From: [REDACTED]
Sent: 20 March 2023 09:33
To: Planning
Subject: Re:Cherry Hall-Planning Application Ref. 3/2022/1181

From: [REDACTED]
Sent: 22 March 2023 20:06
To: [REDACTED]
Subject: planning application number 3/2022/1181 to extend Cherry Hall, Main St, Grindleton.

I am writing to express my opposition to the planning application number 3/2022/1181 to extend Cherry Hall, Main St, Grindleton.

Datum 28.00
South Elevation

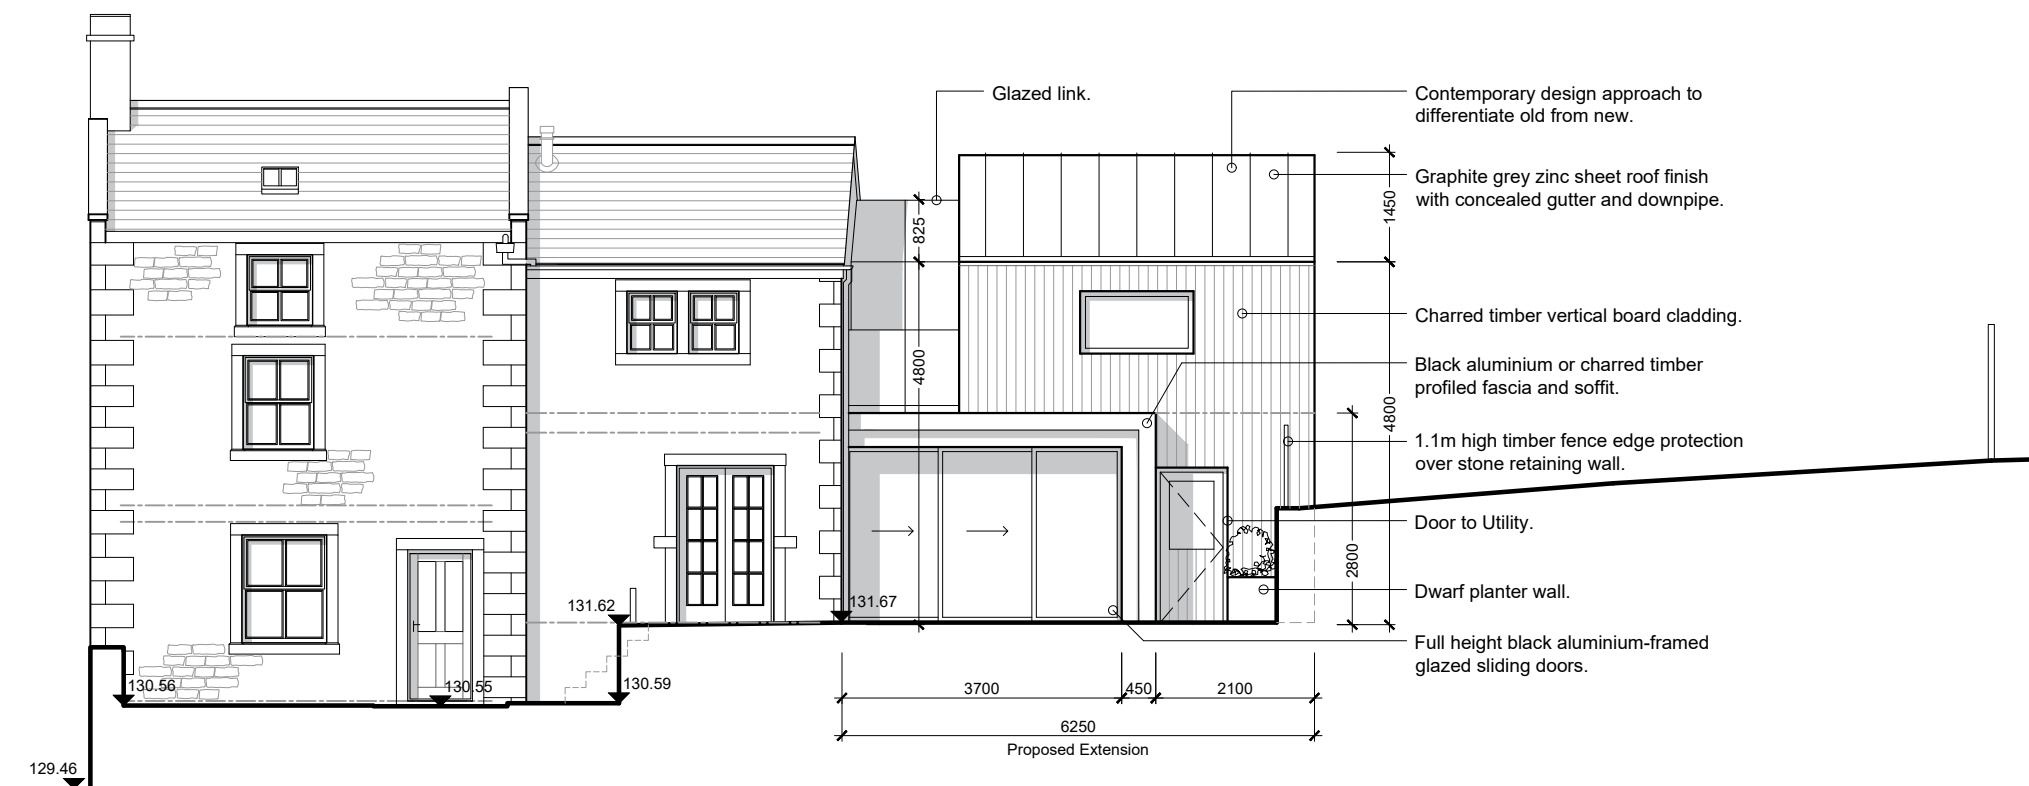
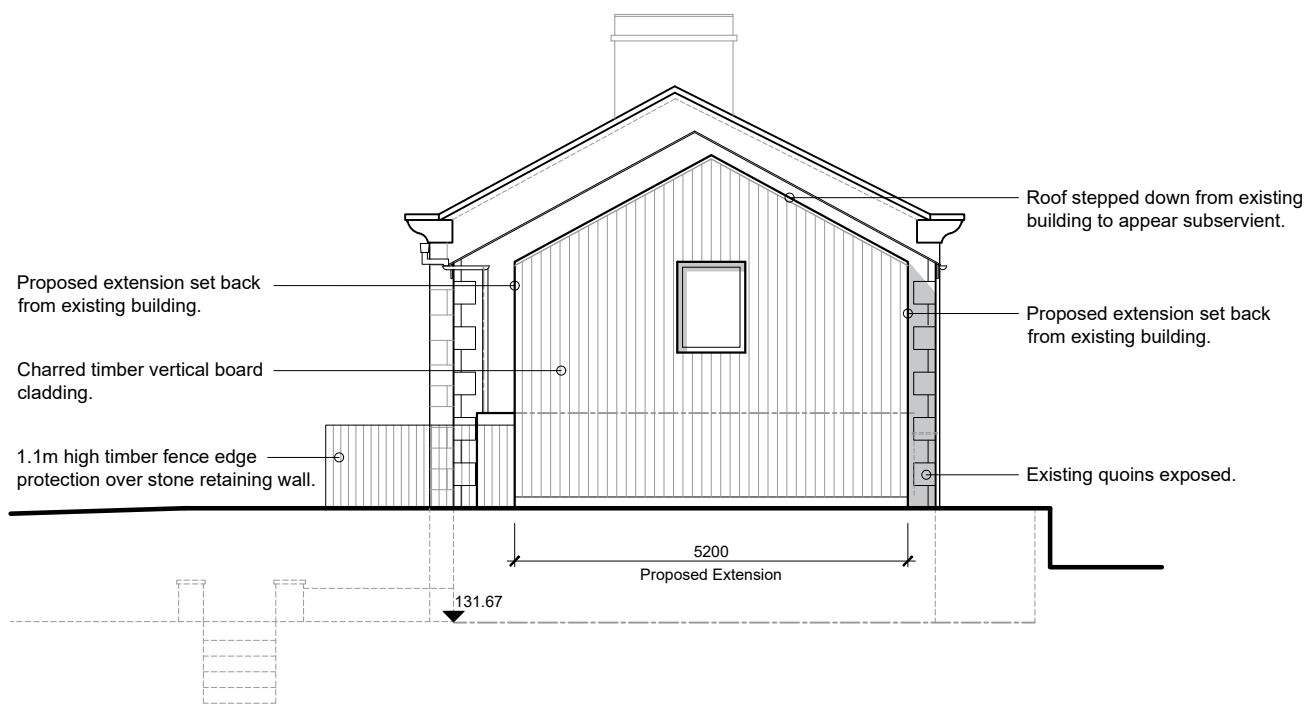
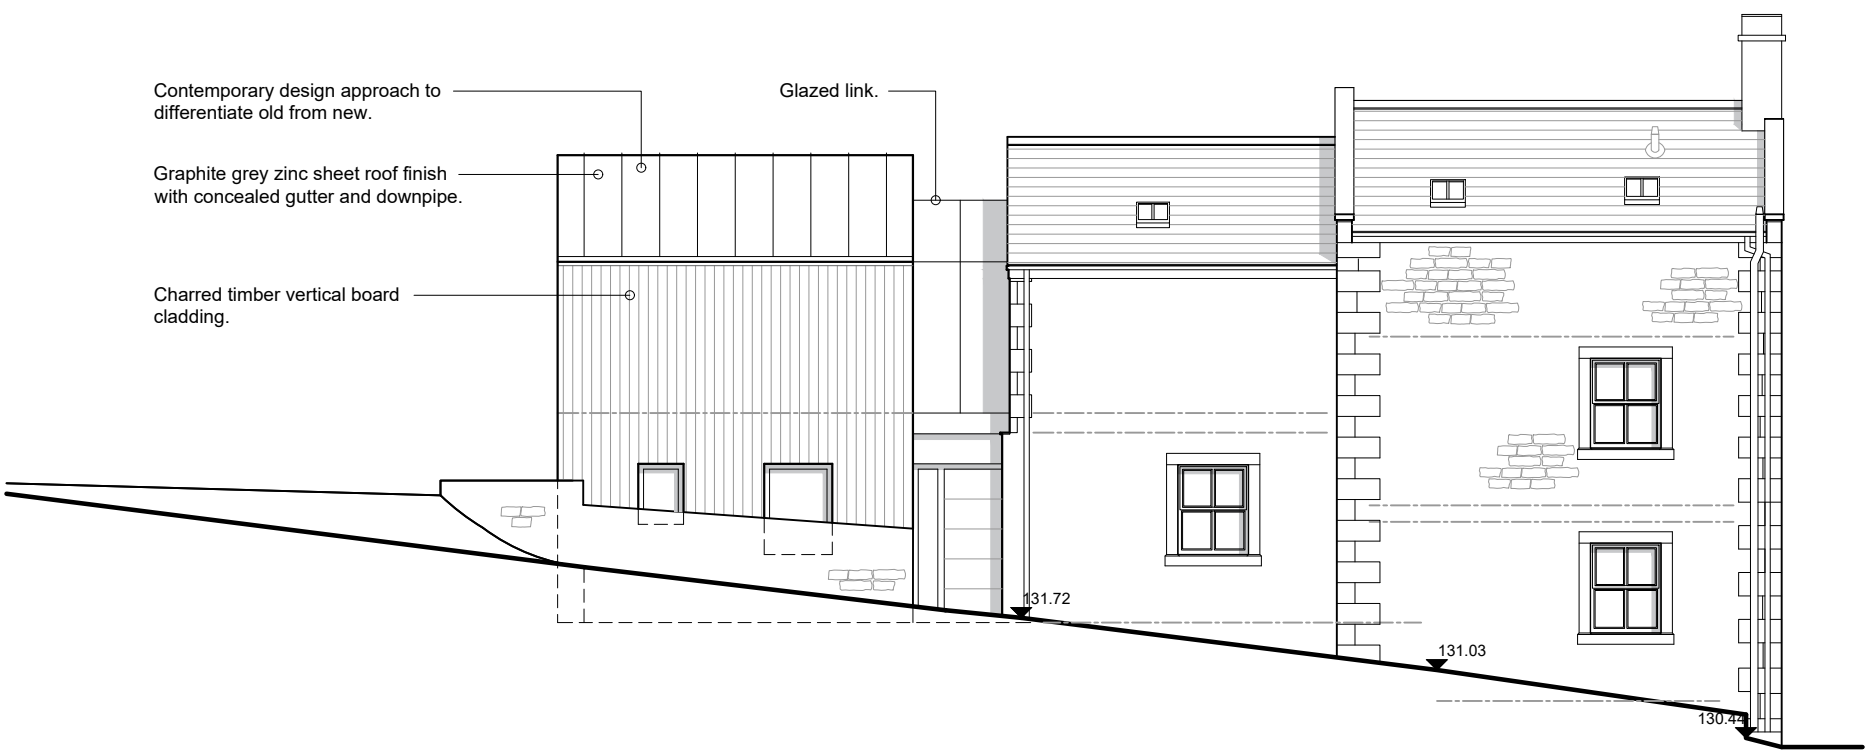
The material selection and modern nature of the proposed extension will change the very character of the outlook from [REDACTED] and the surrounding area, at present a classic historical village view within the AONB. The extension will be clearly visible from Main Street and the public bridleway.

- (g) ~~Materials used should be sympathetic to the character of the area.~~
(h) **Materials used should be sympathetic to the character of the area.**

The materials detailed are not in keeping with the historic village located within the conservation area.

I am also concerned regarding the reflective properties of the glazing and the zinc roof which may impact on longer distance views of the village. Reflection of sunlight can be visible for long distances and may be visible from Pendle Hill and its surrounds.

Ground Floor Plan

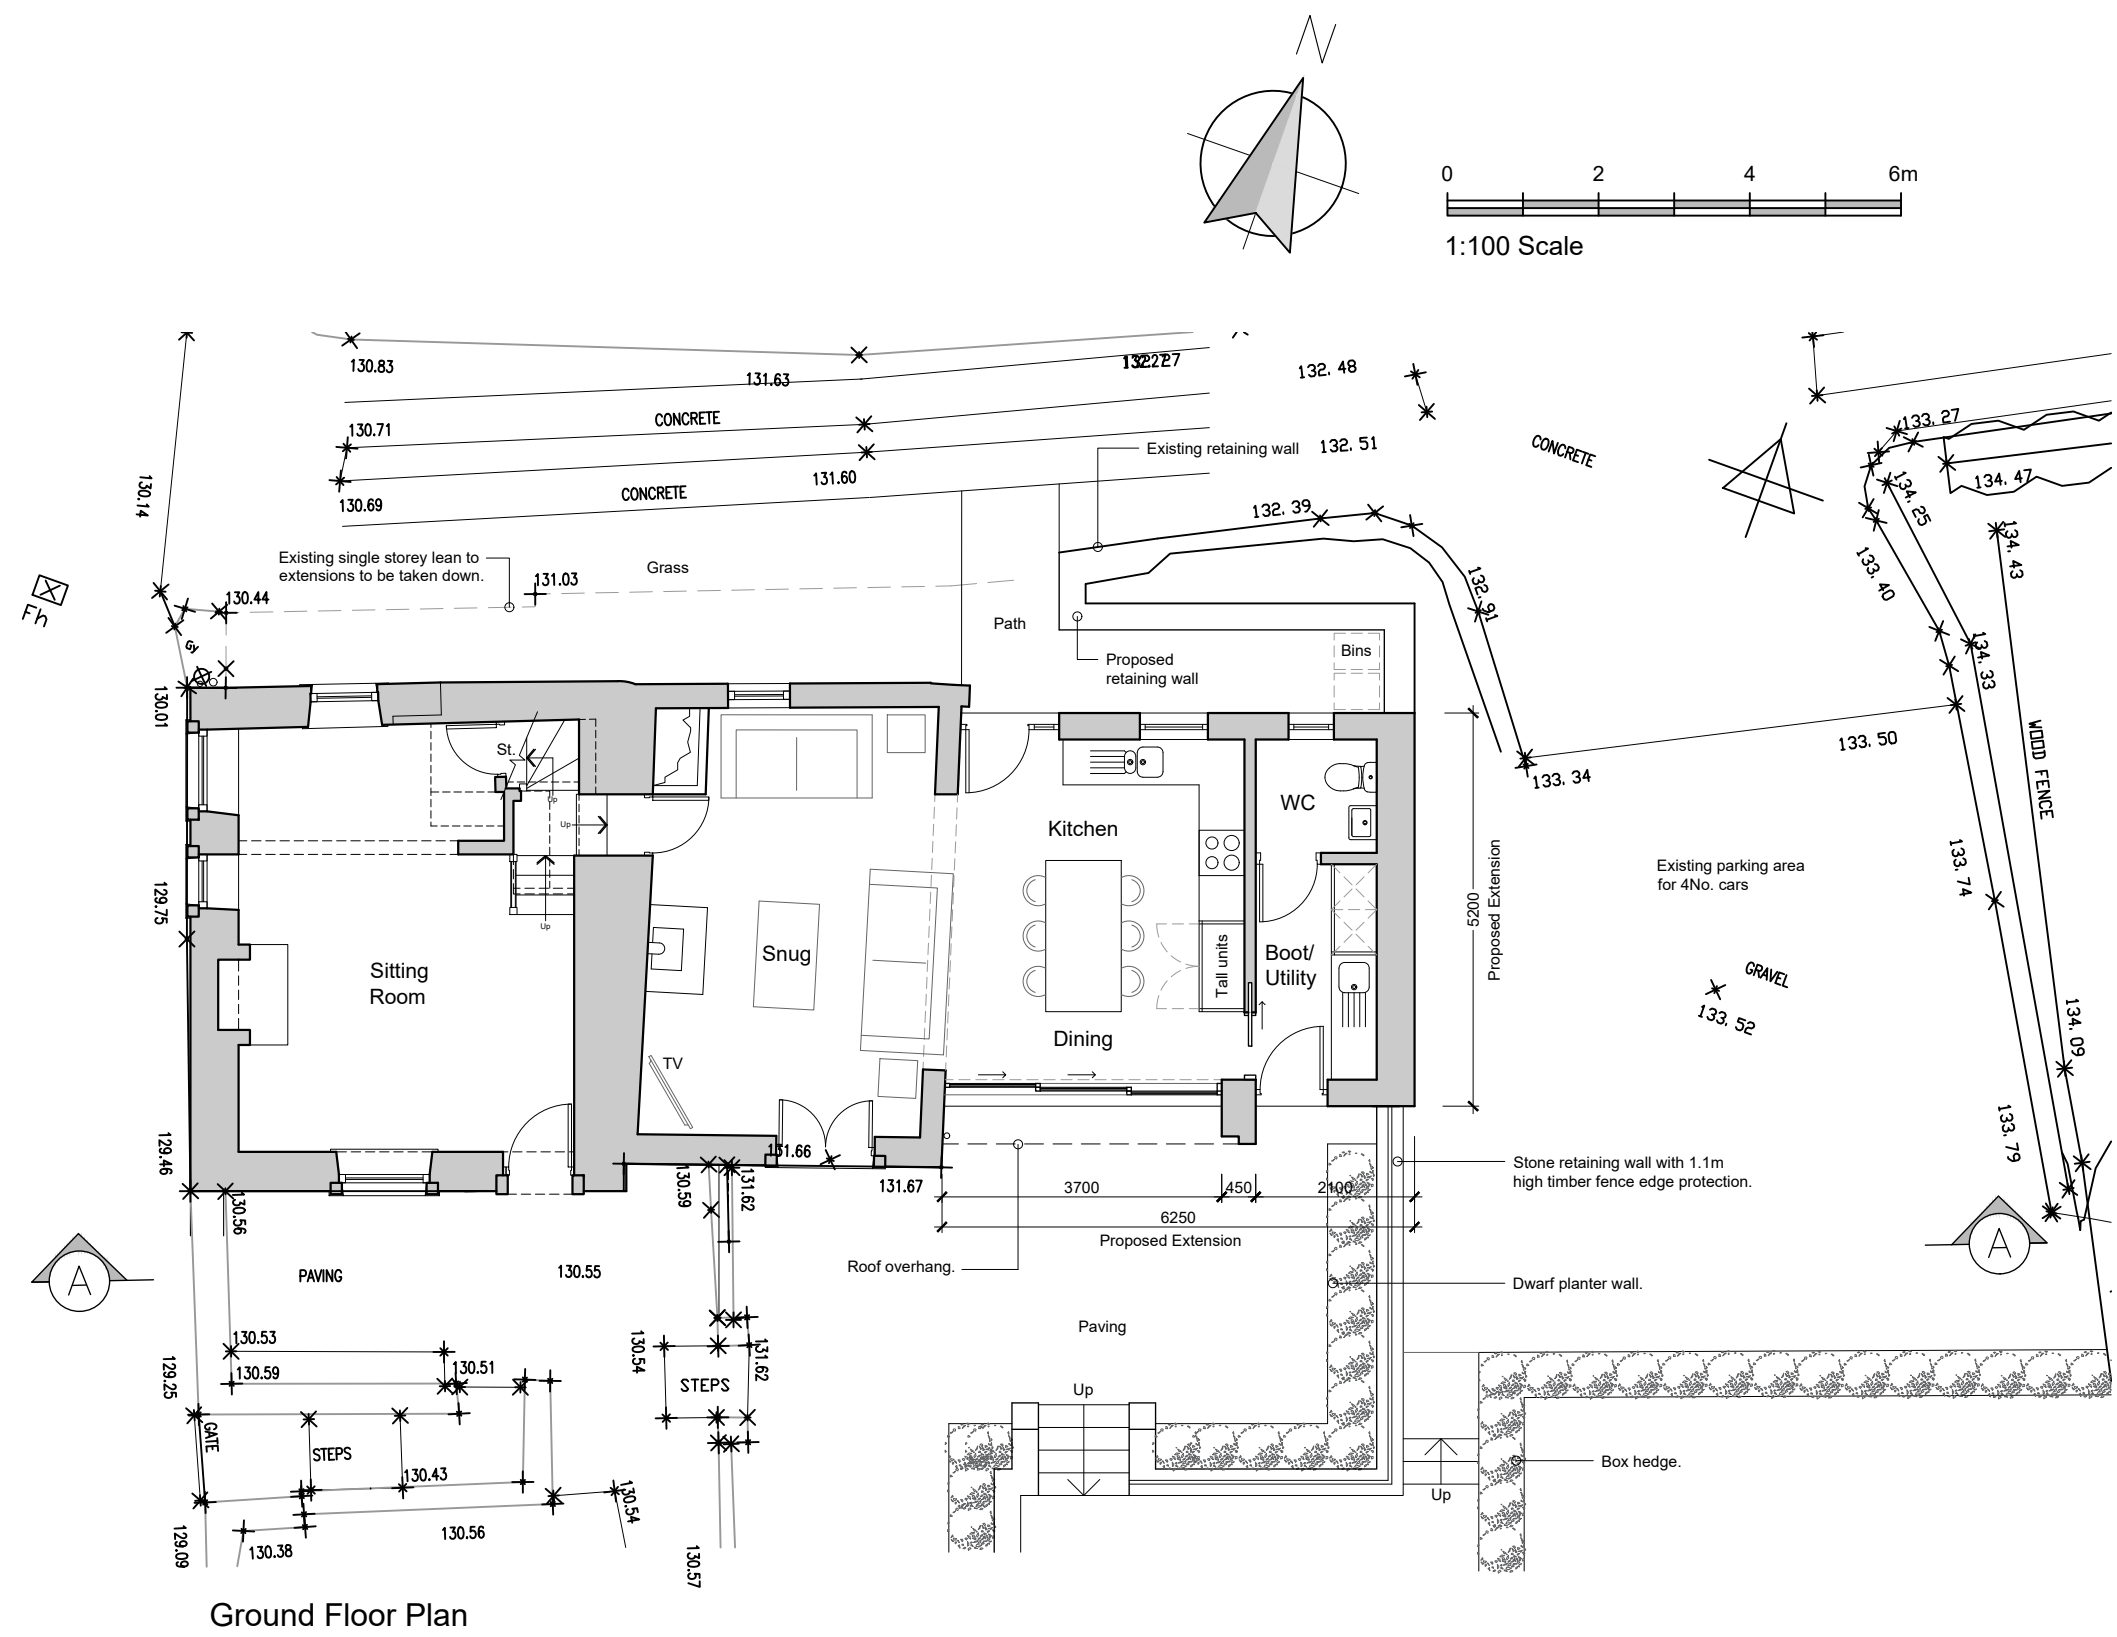
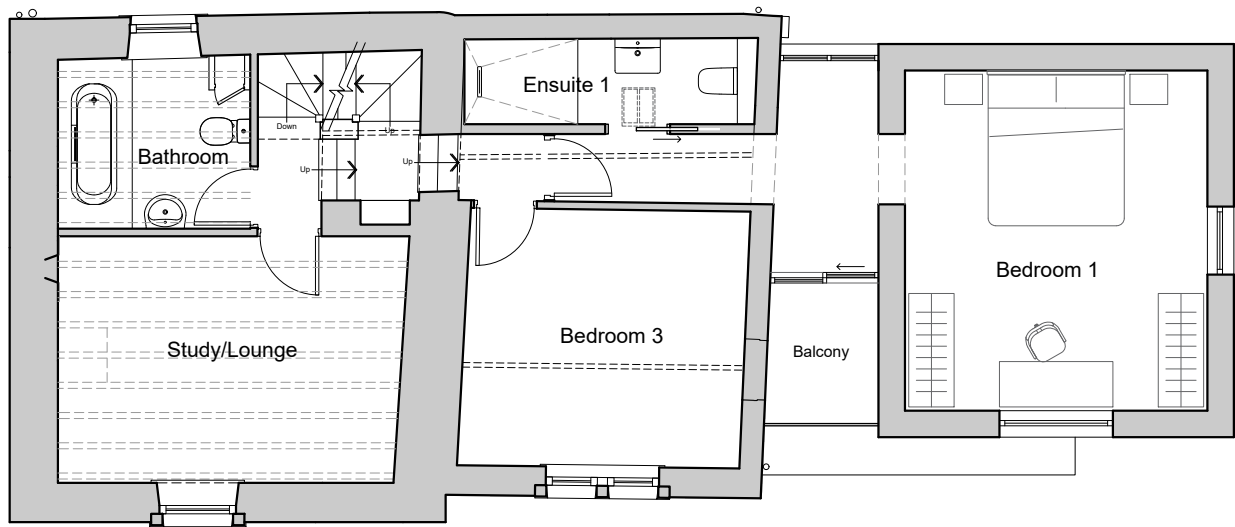
The proposed plan details a new two storey glass walkway between the new extension and the existing house. [REDACTED] At present there is a single, [REDACTED] The presence of the glass walkway, at a higher level. [REDACTED]

[REDACTED] This glass walkway is a somewhat strange feature as it links the new master bedroom and its 'ensuite bathroom' so will also impact on the privacy of any future occupants of Cherry Hall.

I am also concerned about the additional window shown in the plans in the second floor bathroom. This has not been detailed on the north elevation,

In addition, the additional window above the sink in the new kitchen will also [REDACTED] [REDACTED] Whilst this is at a lower level and arguably gives the same view as could be obtained

I have additional concerns related to the potential for light pollution from the detailed glass atrium. During the day time this will allow natural light in through the house to the kitchen diner area on the ground floor – and hence, at night time, the lights on in those most used areas of the house will result in light pollution that will be seen, both locally in the village but also will be seen from far reaching views from the Pendle Hill area,
